Our ref: Project Pluto Data Centre (SSD-69223466)

26 August 2025

Subject: Request for Additional Information

I refer to the Submissions Report for the Project Pluto Data Centre (SSD-69223466) at 132 McCredie Road, Guildford West, within the Cumberland local government area.

GENERAL NOTES
This drawing is provided for information purposes only and should not be used for construction.
Aerial photograph (taken 13 Mar 2024) obtained from Nearmaps.

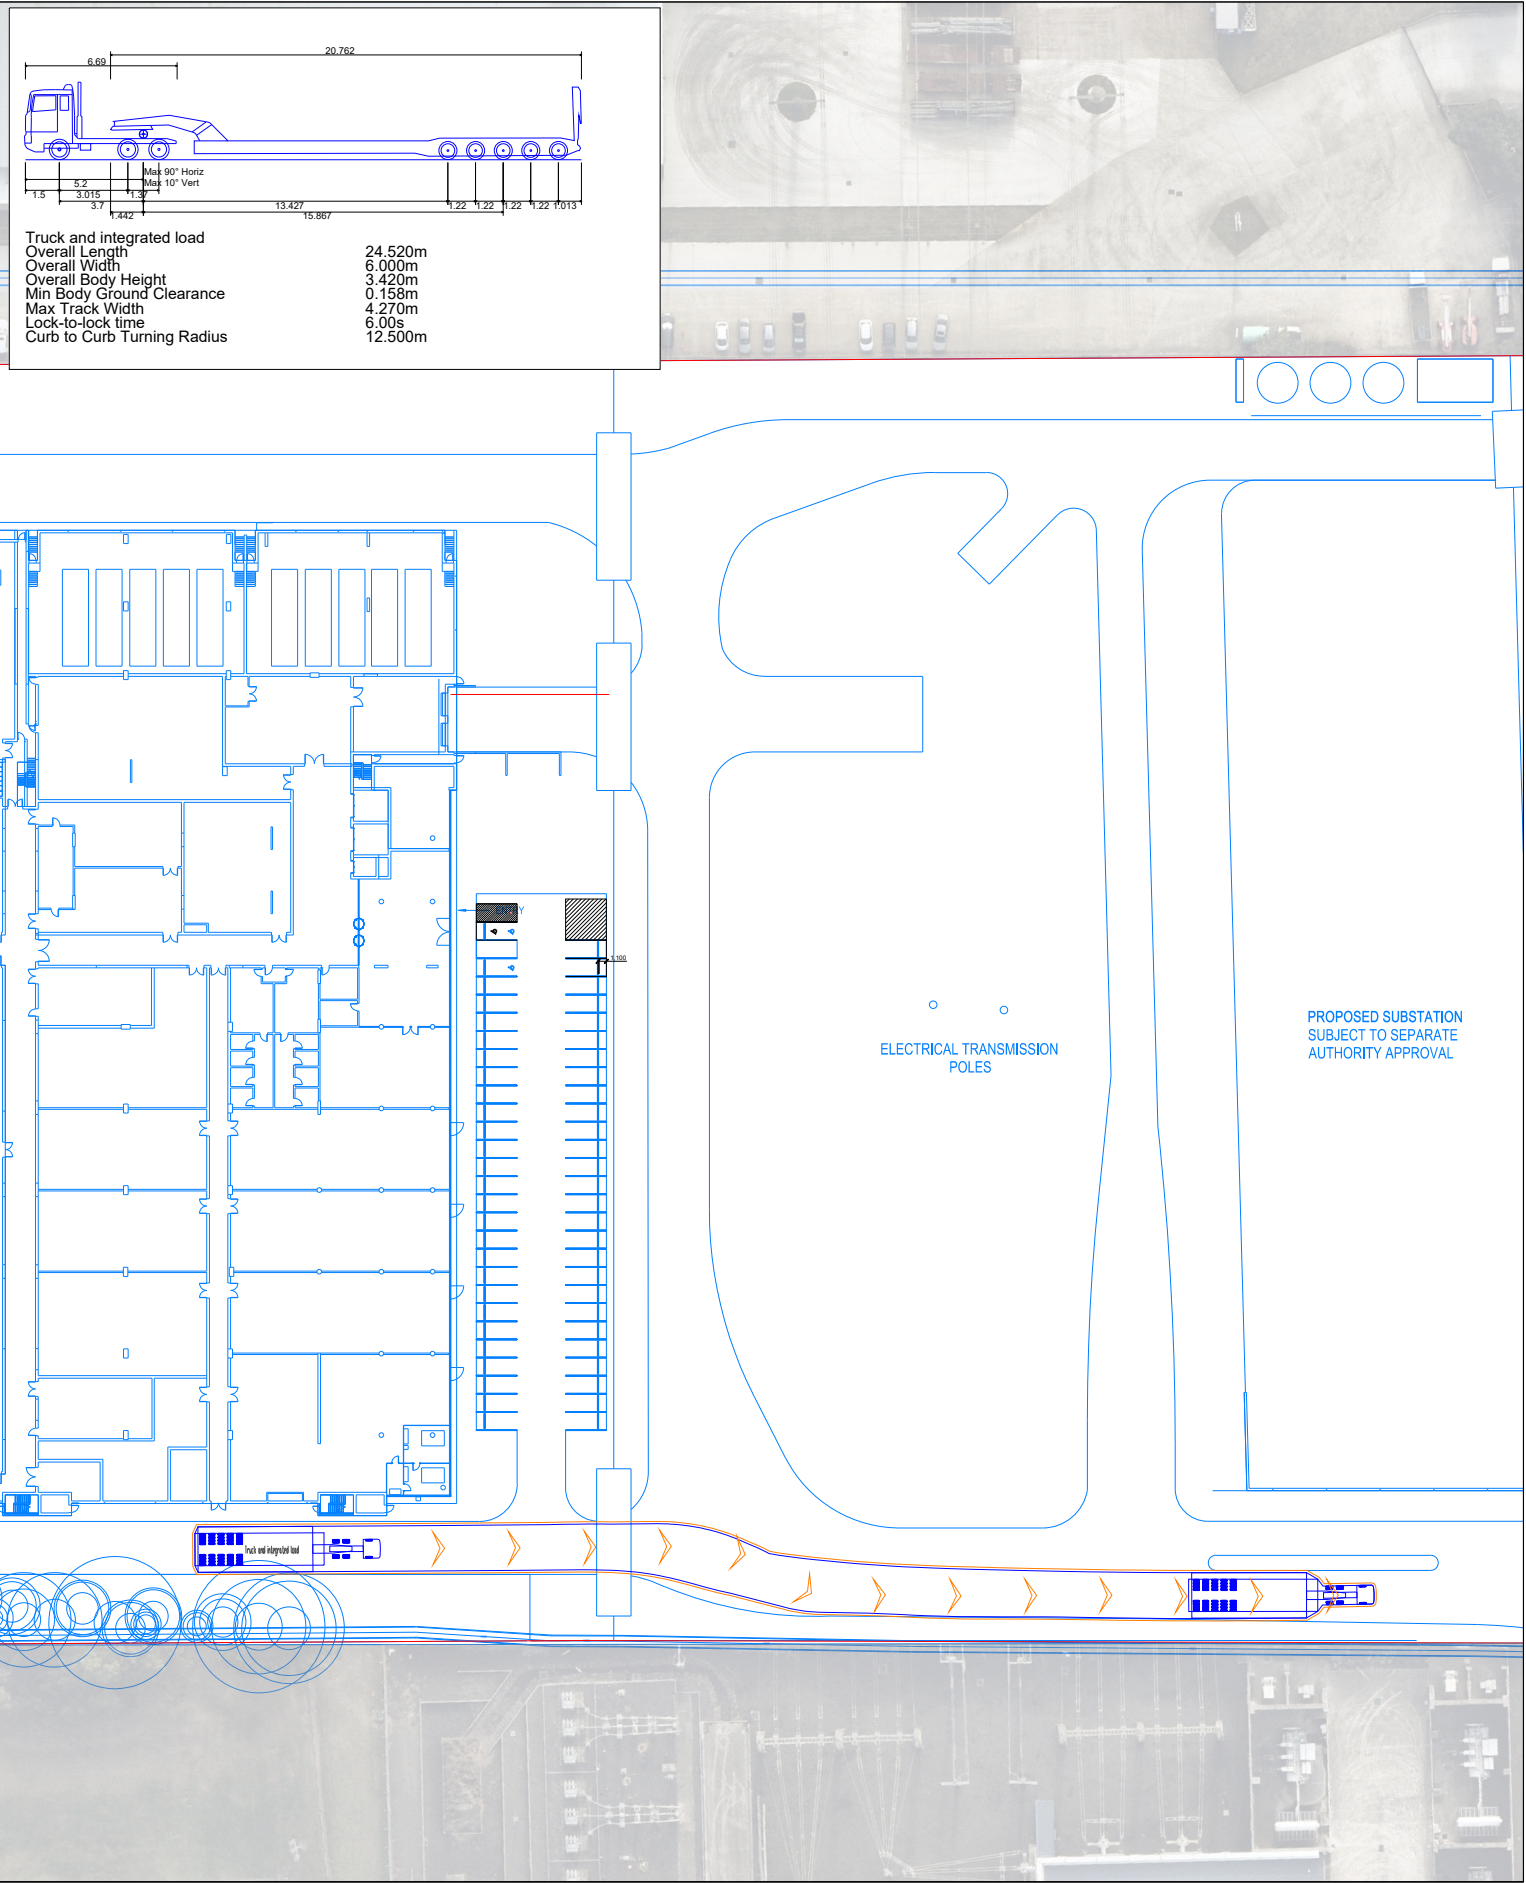
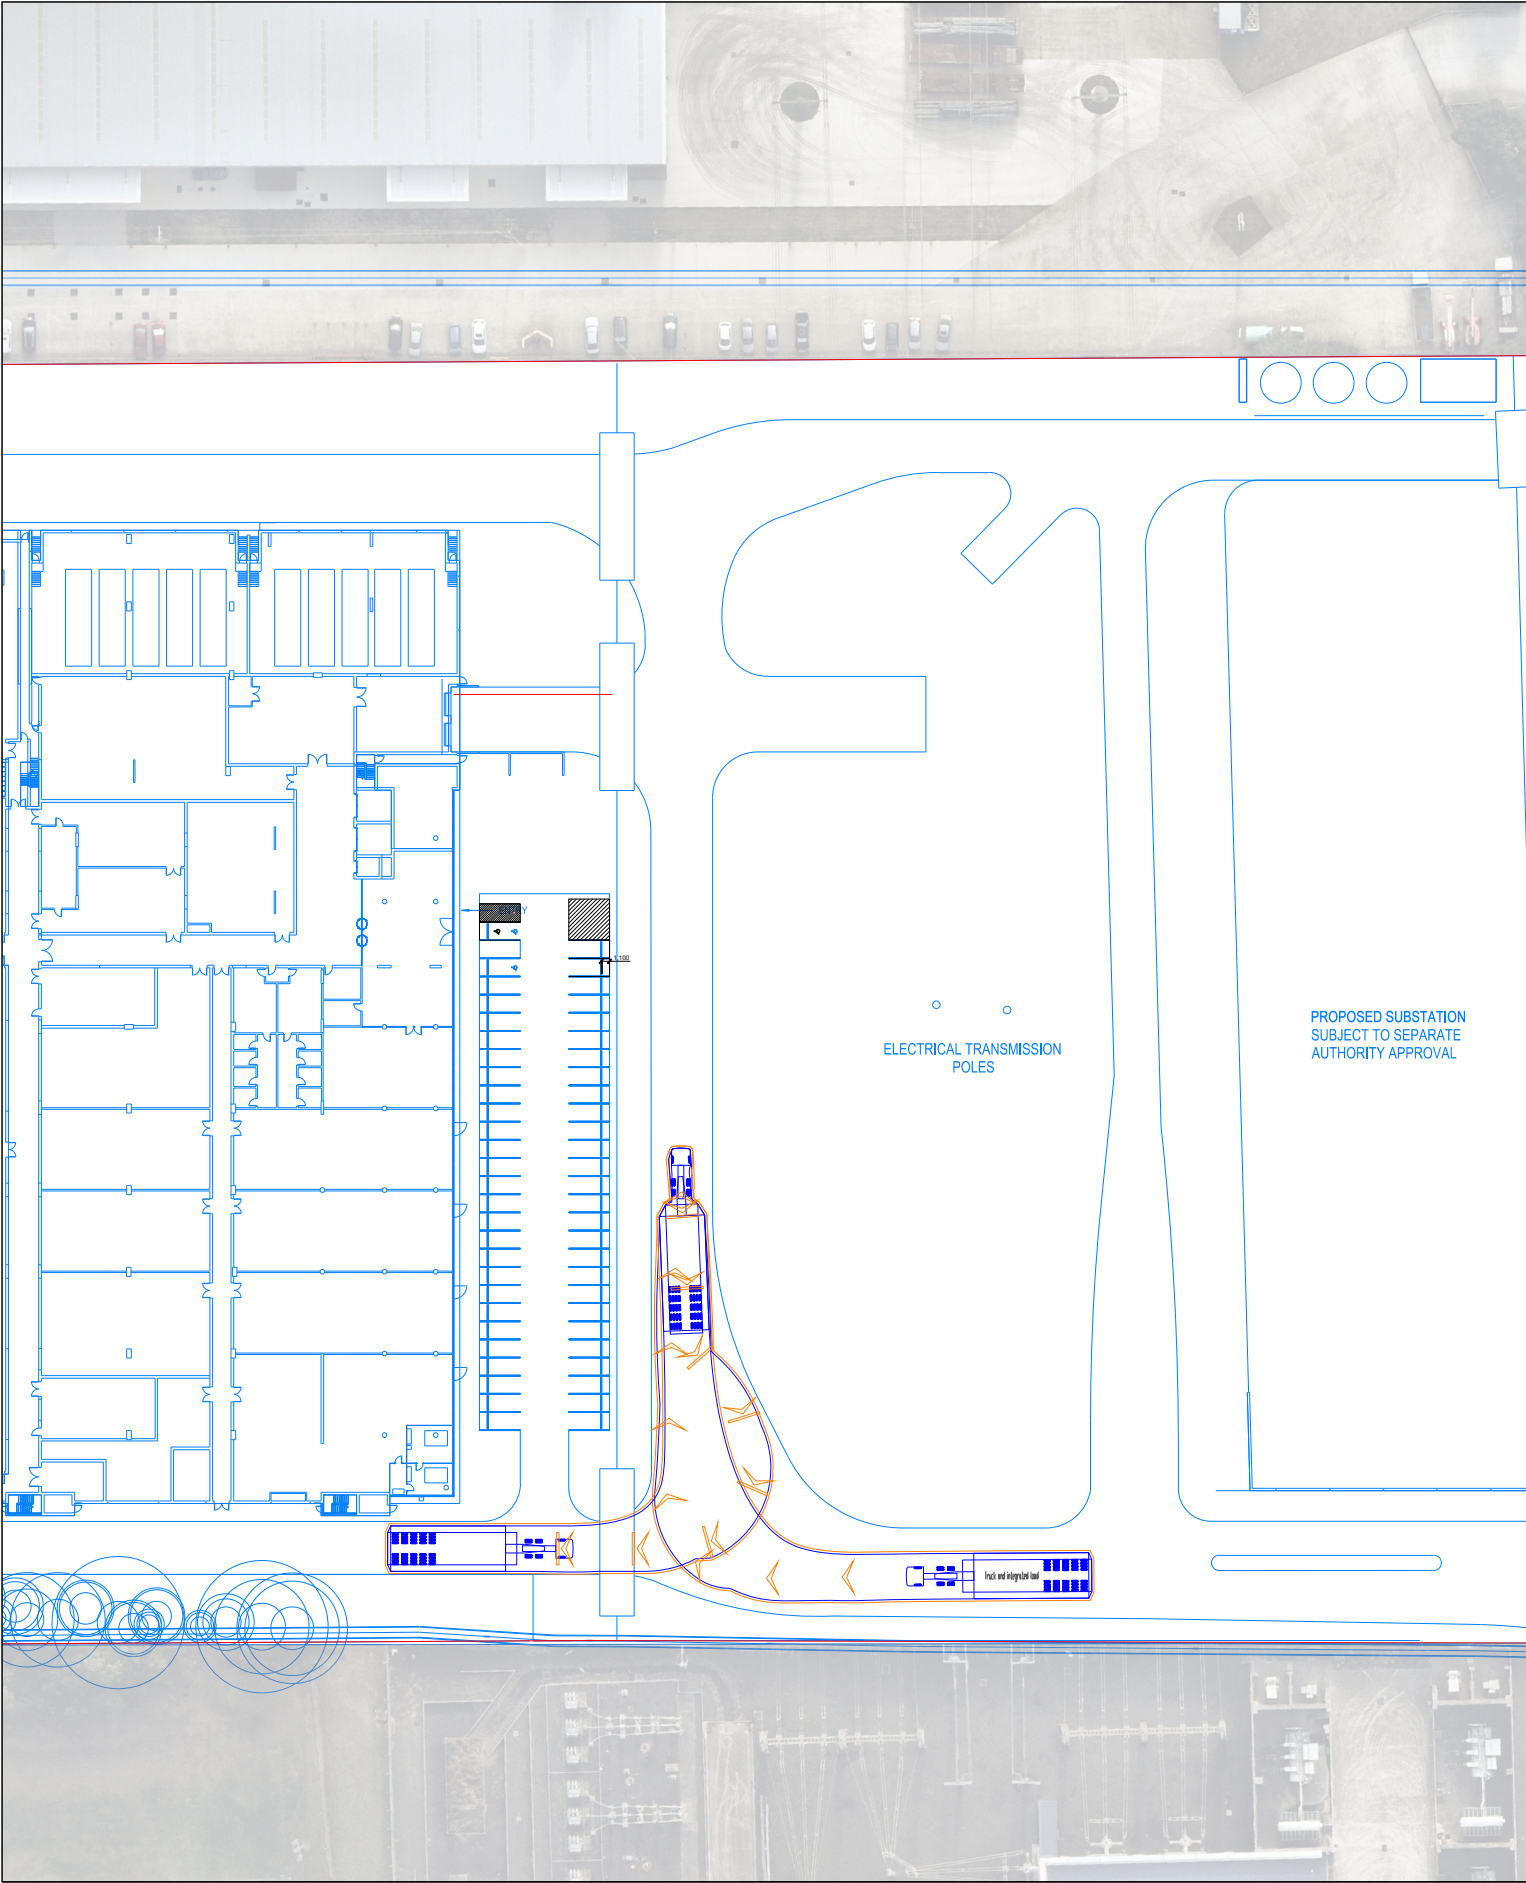
2. The Department's previous concerns regarding the movement of heavy vehicles in and out of the site has not been adequately addressed. The provided SWEPT path analysis diagrams appear to continue to demonstrate that heavy vehicles cannot enter and exit the uninhibited. The proposed site access arrangements should be updated to accommodate the anticipated largest vehicles to access the site or be restricted from access and smaller vehicles considered for site operations.
